ENG-PUDSP21010-R7-PDR.pdf Markup Summary

EX-1

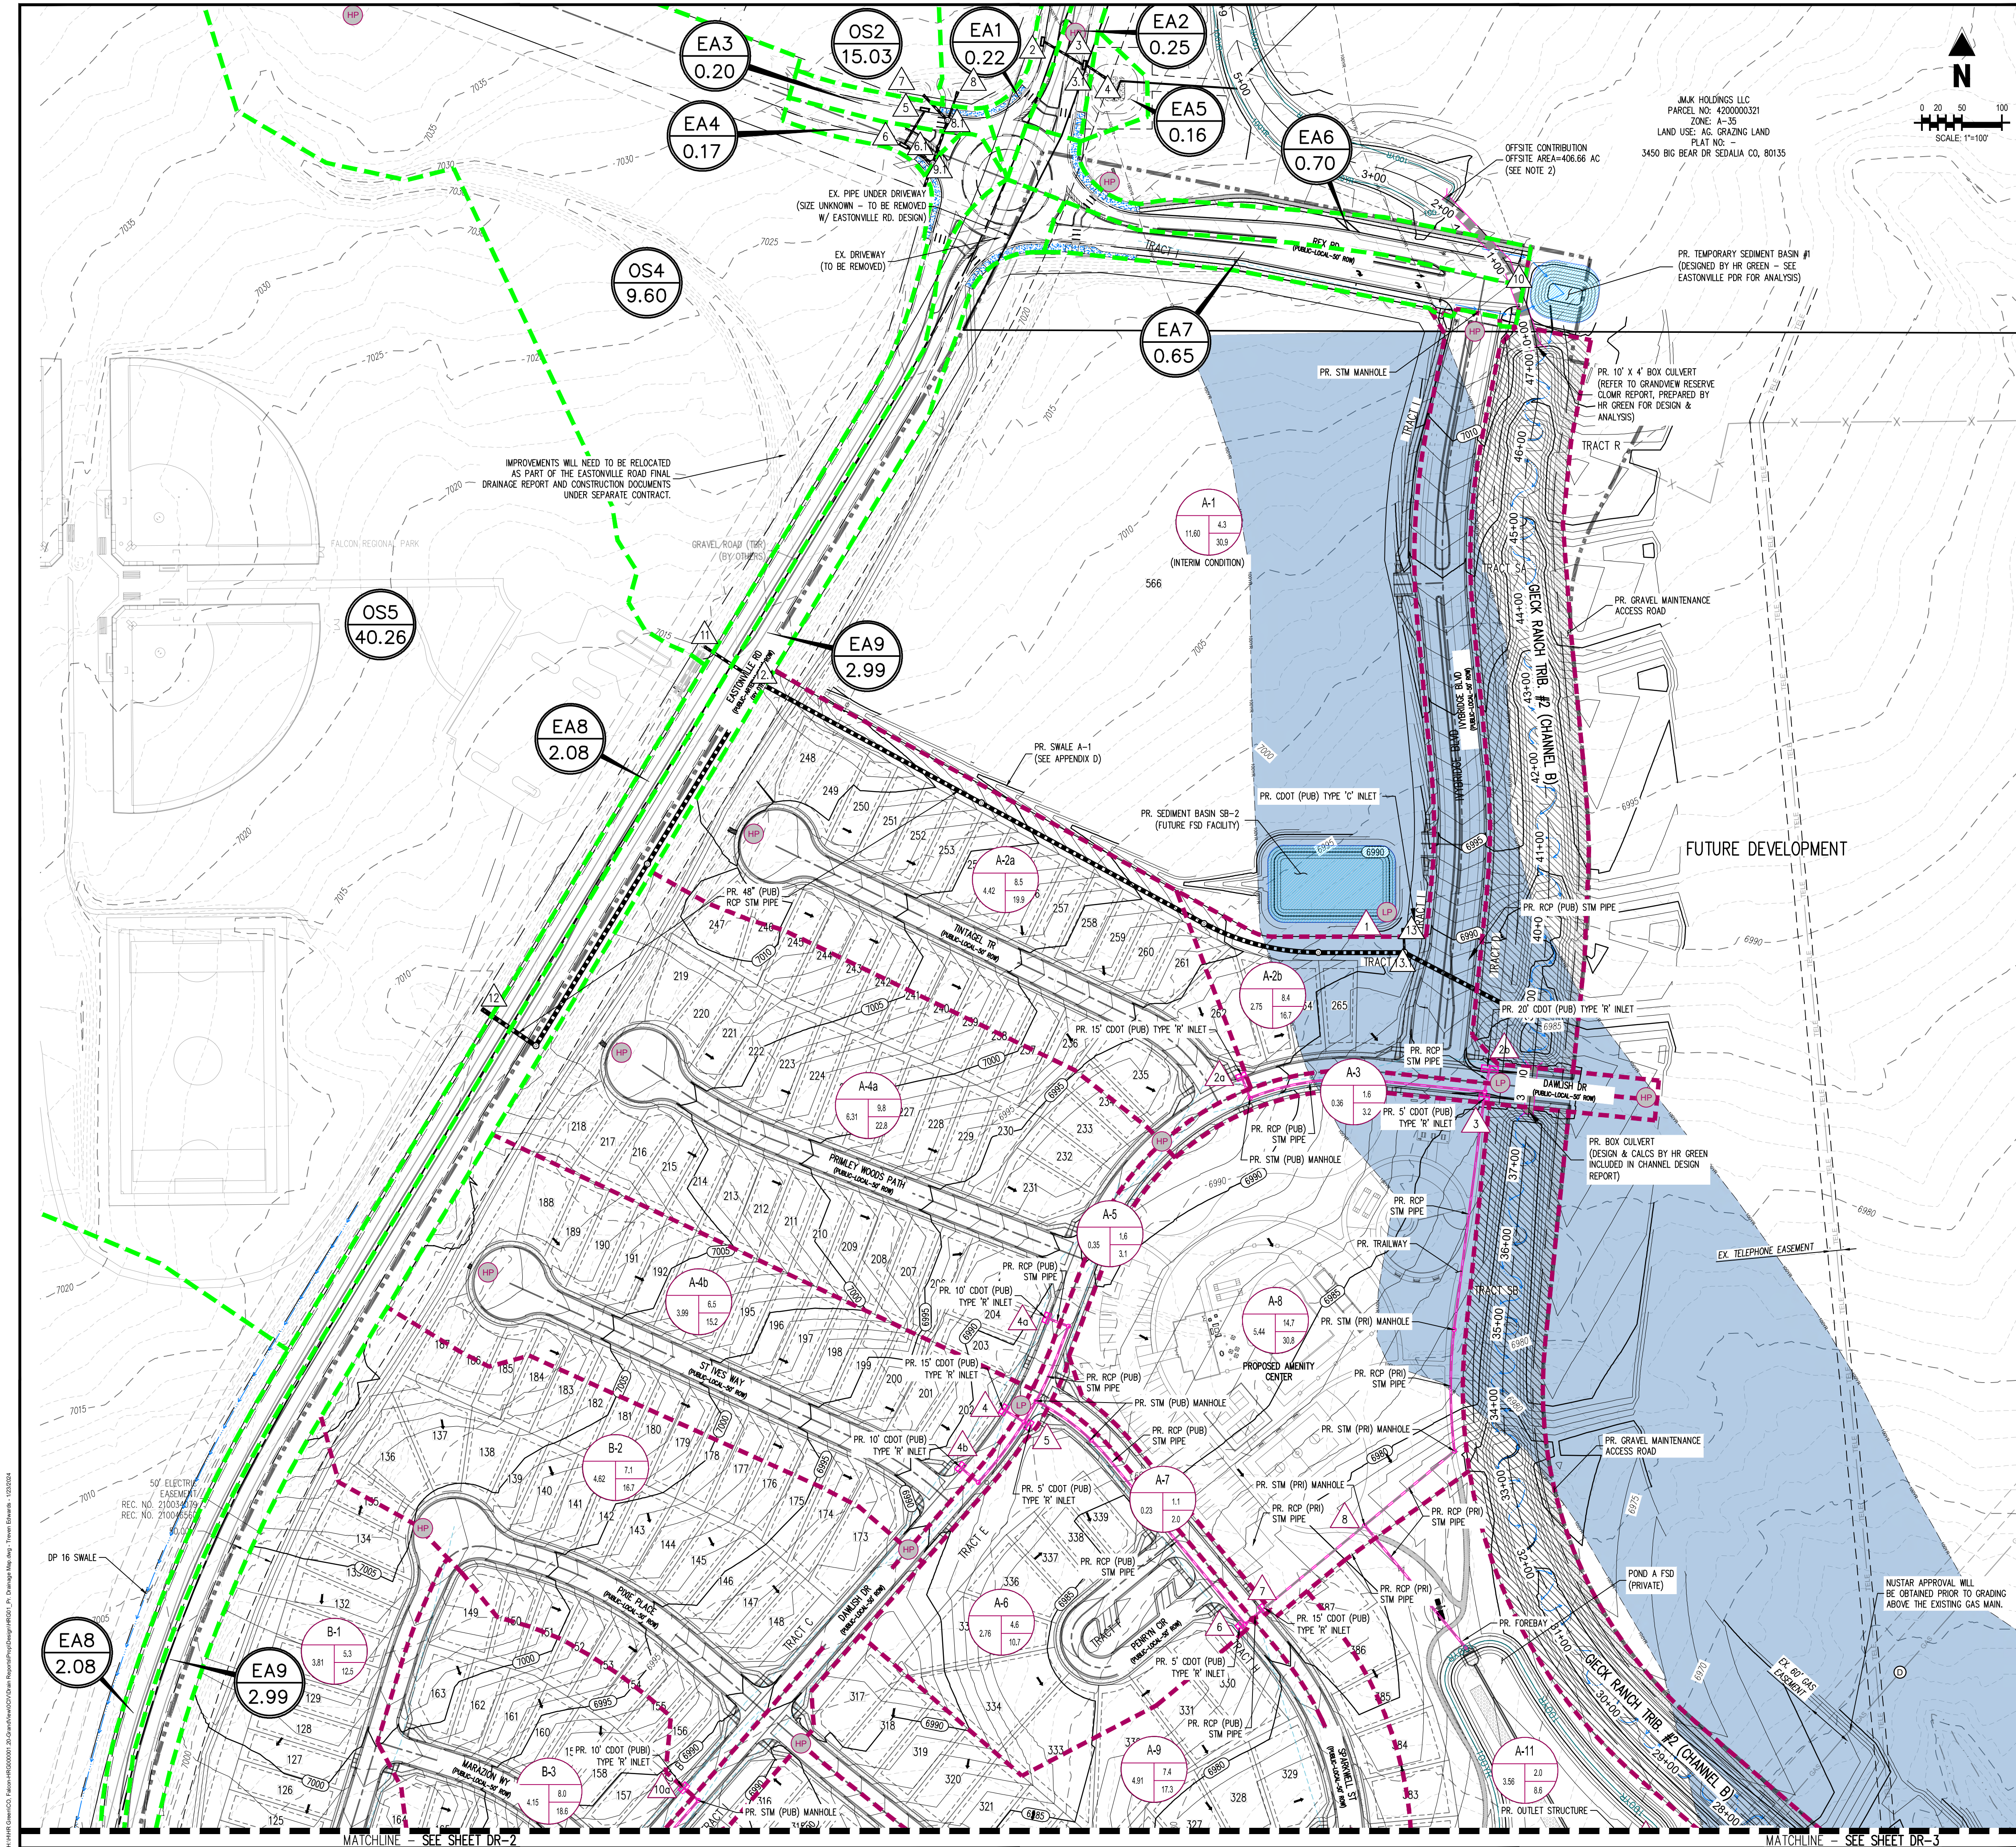
missing values, please make tables clearer

Missing drainage basin summary table (all sheets)

EASTONVILLE ROAD
 D.R. HORTON
 EL PASO COUNTY, CO

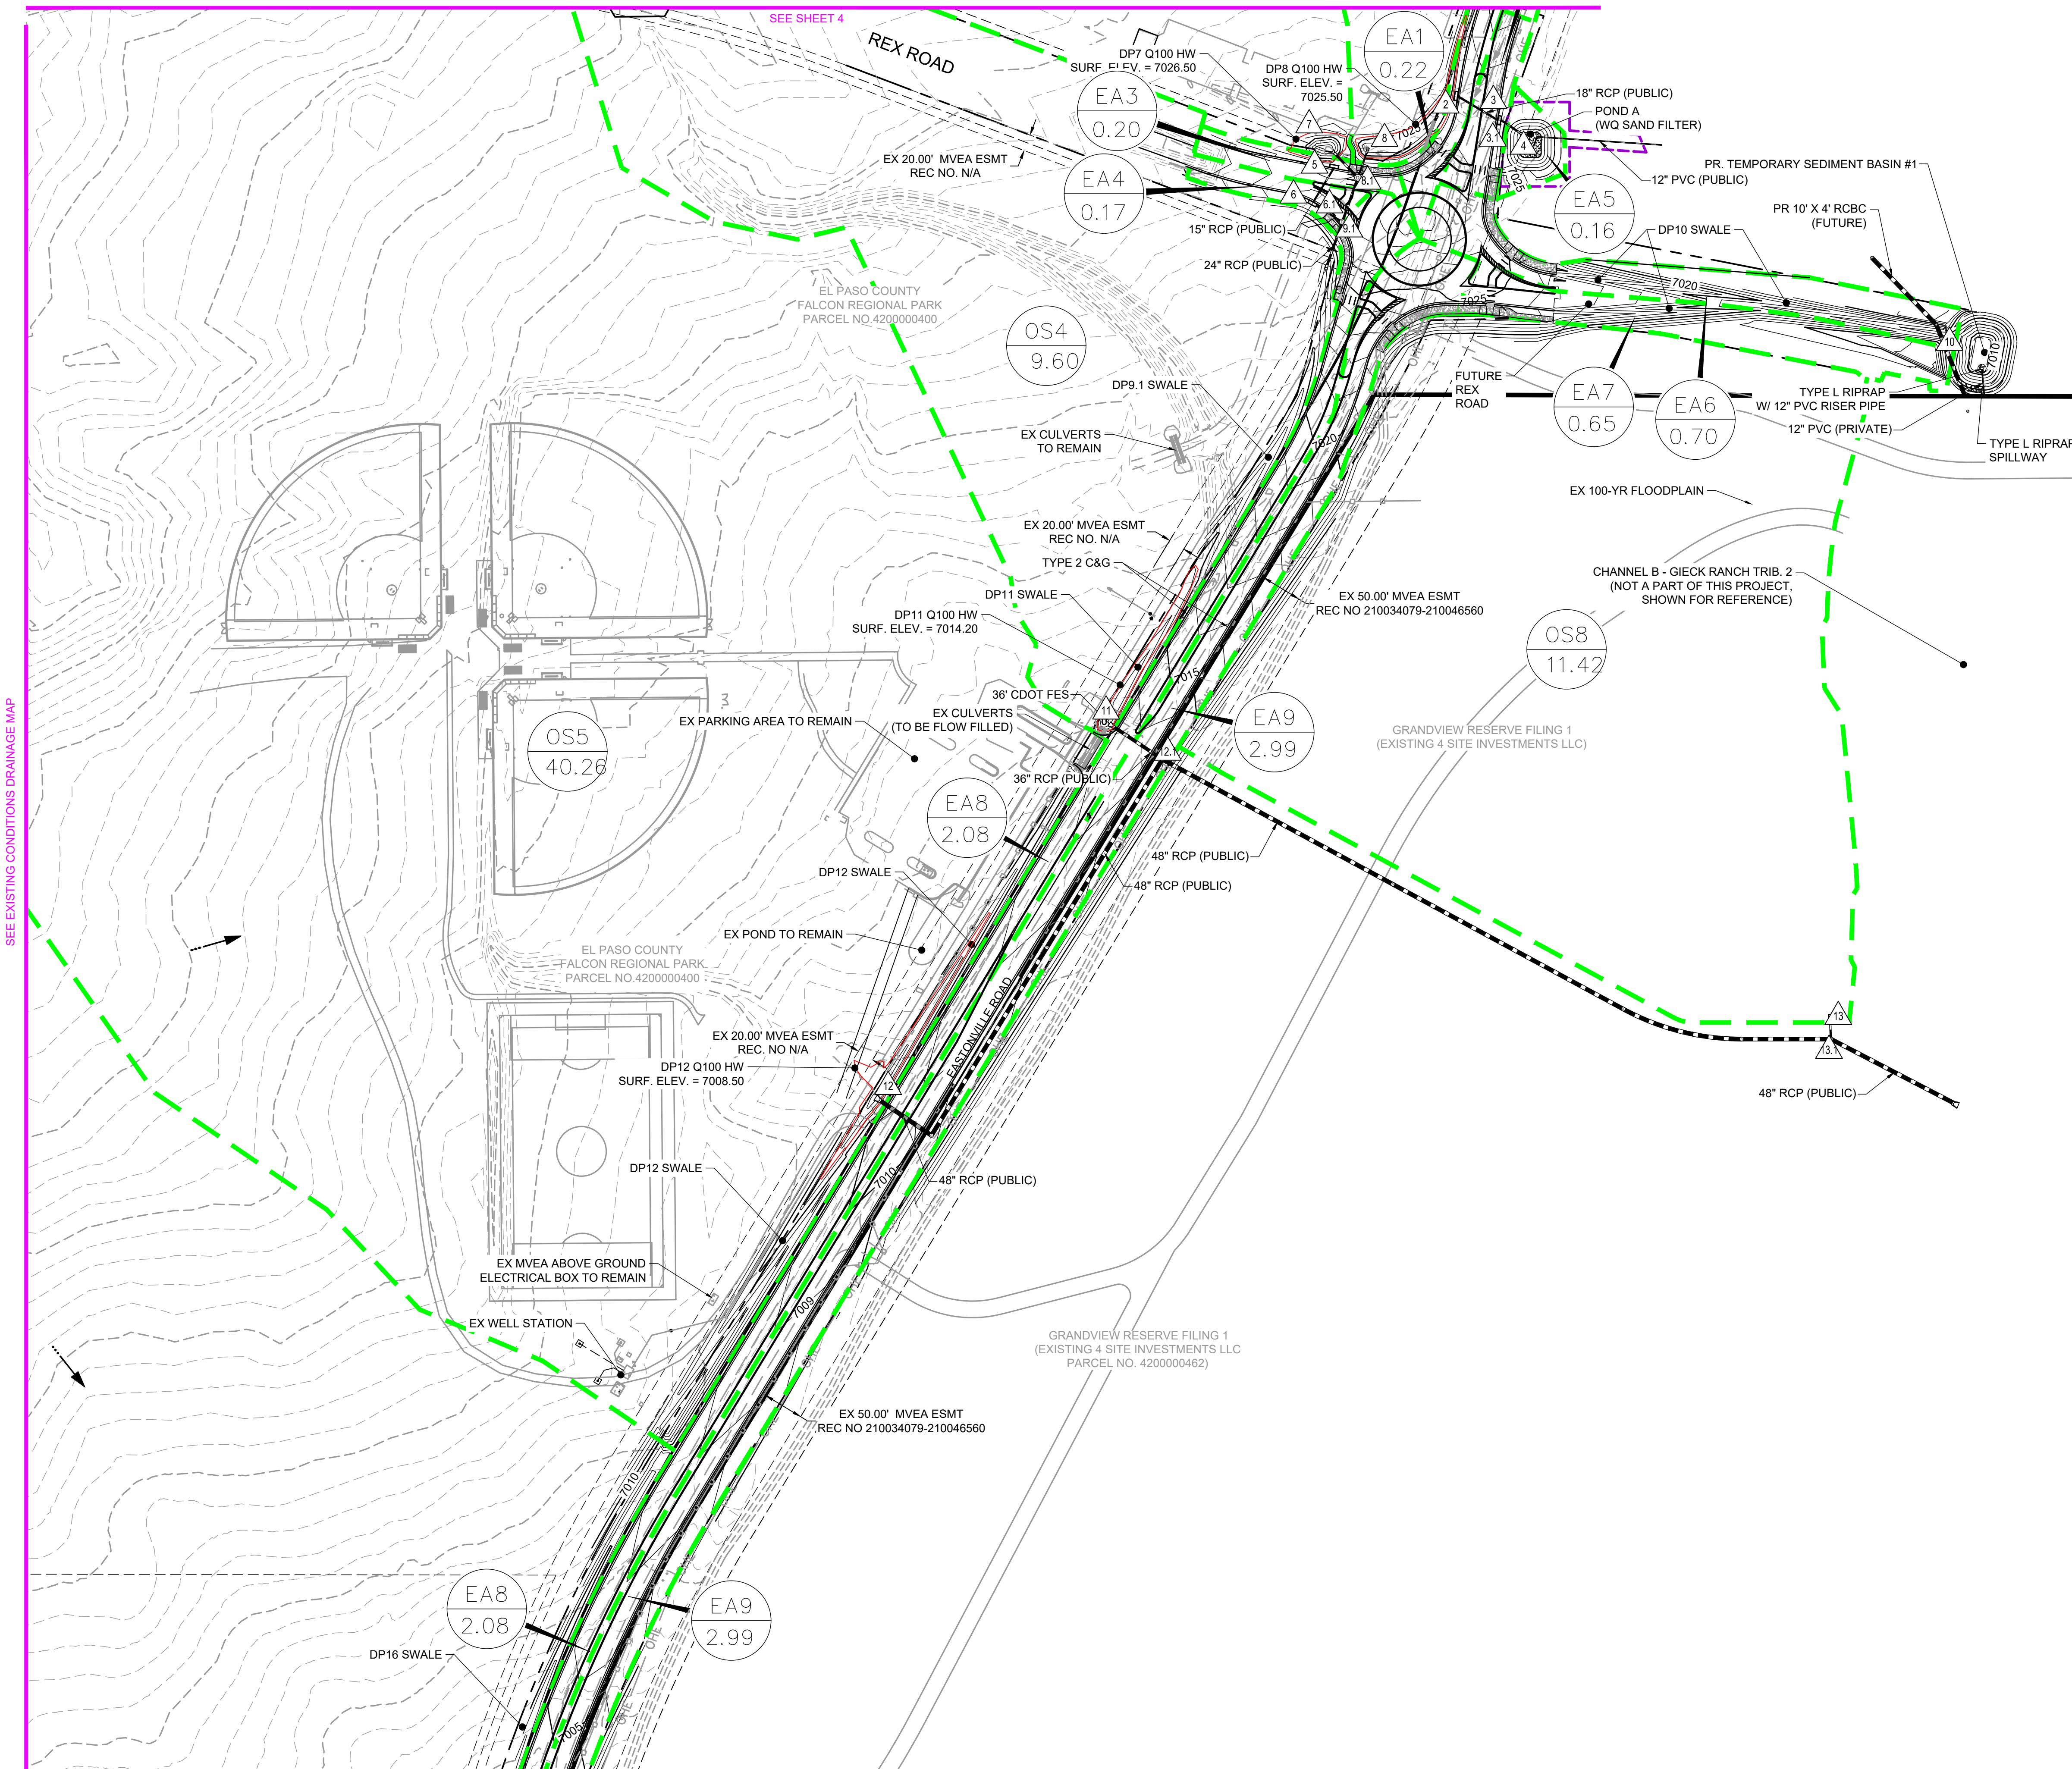
Flow per summary table on drainage map shows DP EA1 with a flow of 19.5 cfs
